**KIRKLEES METROPOLITAN COUNCIL  
INVESTMENT & REGENERATION SERVICE**

**DELEGATED DECISION TO DETERMINE PLANNING APPLICATIONS**

Reference No:	<b>2023/62/90932/E</b>
Site Address:	16, Camroyd Street, Dewsbury, WF13 1PE
Description:	Change of use of land to domestic use, Erection of two storey side extension, two storey rear and single storey front extensions, drop kerb and associated alterations
Recommending Officer:	Jennifer Booth

## **OFFICER REPORT**

Proposed Rear Elevation

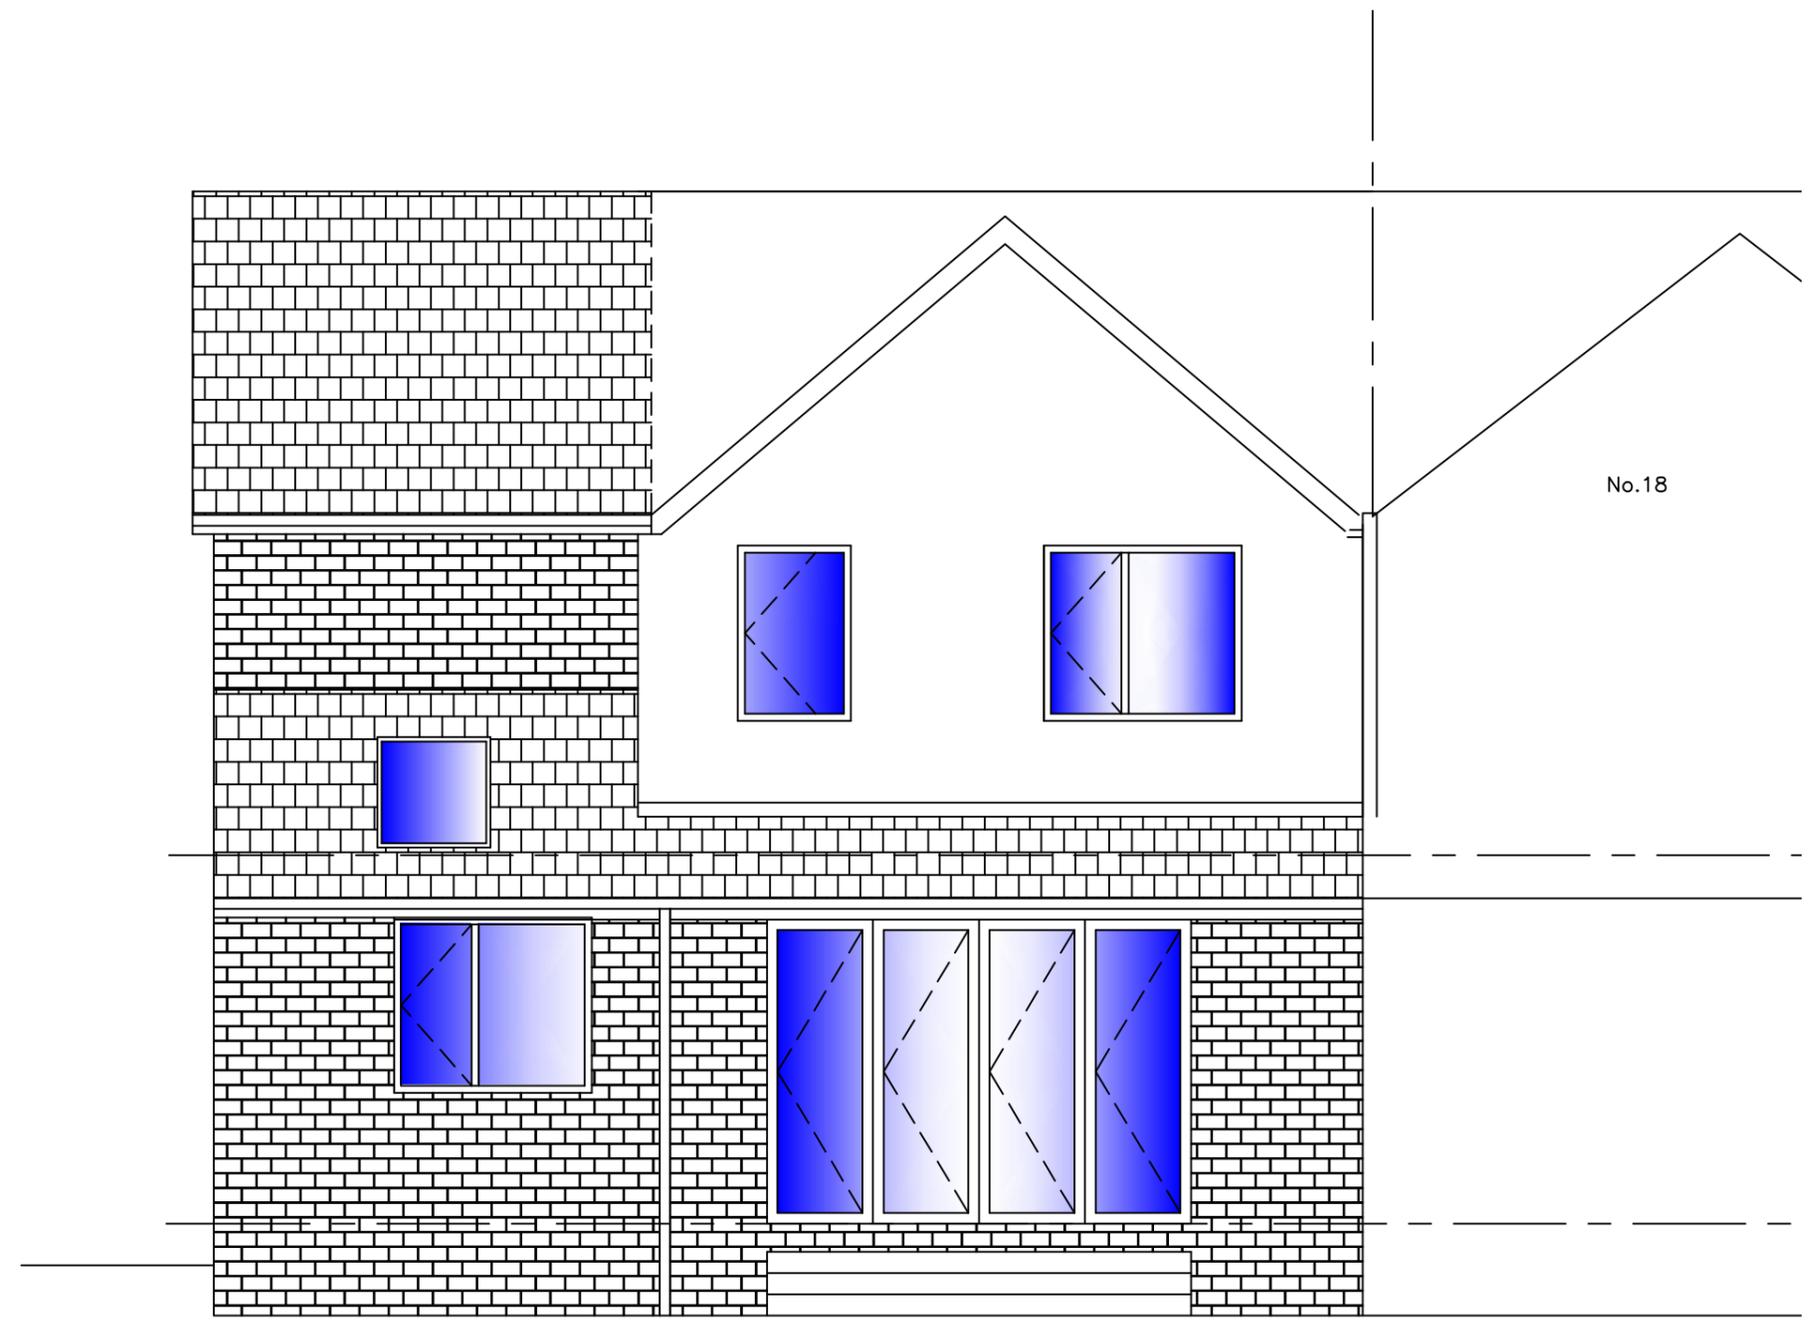
The single & two storey rear extension would project 4m on the ground floor across the full width of the dwelling- including to the rear of the proposed side extension. Then reducing to 3m at first floor to the rear of the original house only with a perpendicular pitched roof form over the two storey element and lean to over the single storey element.

The scale of the rear extension is similar to the other properties within the row and as such would not be out of character. A modest amenity space would be retained. Furthermore, the materials proposed include the use of brick for the walling and tiles for the roof covering which would match the host dwelling. It is noted that this property has a degree of prominence with its elevated position on the corner. However, the extension proposed can be considered to be acceptable given the appropriate scale relative to the other properties in the row and the use of matching materials. The rear extension is therefore considered to be acceptable in terms of visual amenity.

The dwellings to the rear occupy positions some 20m from the site and at a lower level. However, as the ground floor element would replace an existing outbuilding and the first floor would be limited in terms of its projection to 3m, the impact on the neighbours at the rear is not likely to be significant in terms of overbearing, overshadowing or overlooking.

Proposed Side Elevation

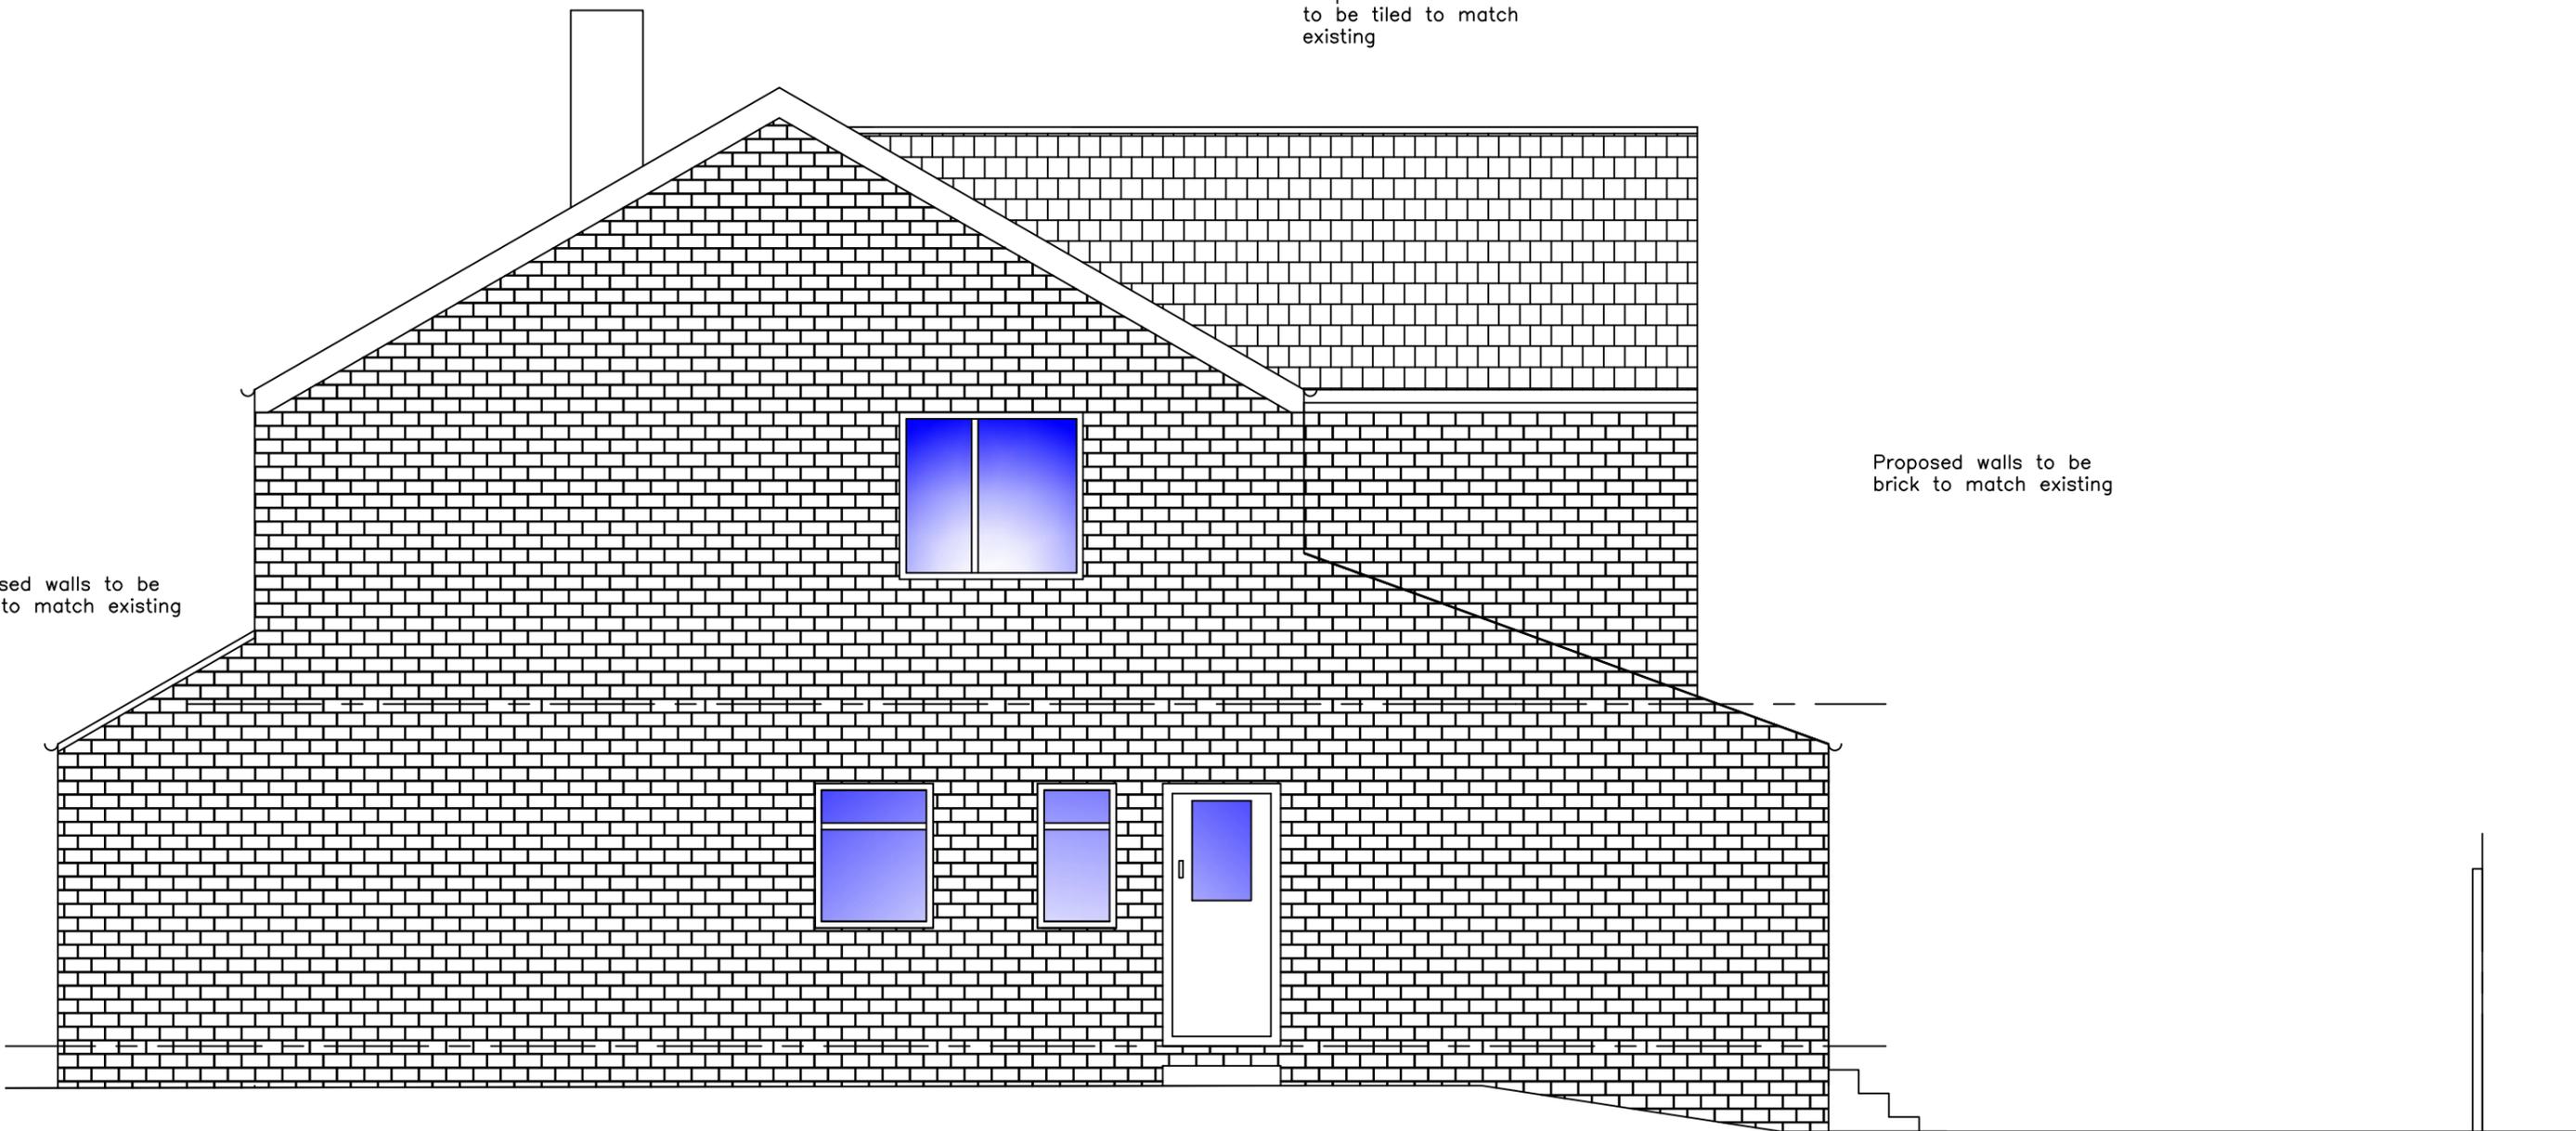
The two storey side extension would project 3m from the original side wall of the dwelling, extending the full depth of the property with a corresponding set down of the roof.

The side extension does not include a set back from the front at first floor with a corresponding set down, which is normally encouraged to allow the formation of a more subservient addition to the property and avoid any potential terracing impact. This is considered to be acceptable in this instance, as the extension at the opposite end of the building group has a similar extension and would help to ensure the existing character of the row, as well as the street scene, is maintained. The materials proposed include the use of brick for the walling with tiles for the roof covering. The side extension is therefore considered to be acceptable in terms of visual amenity.
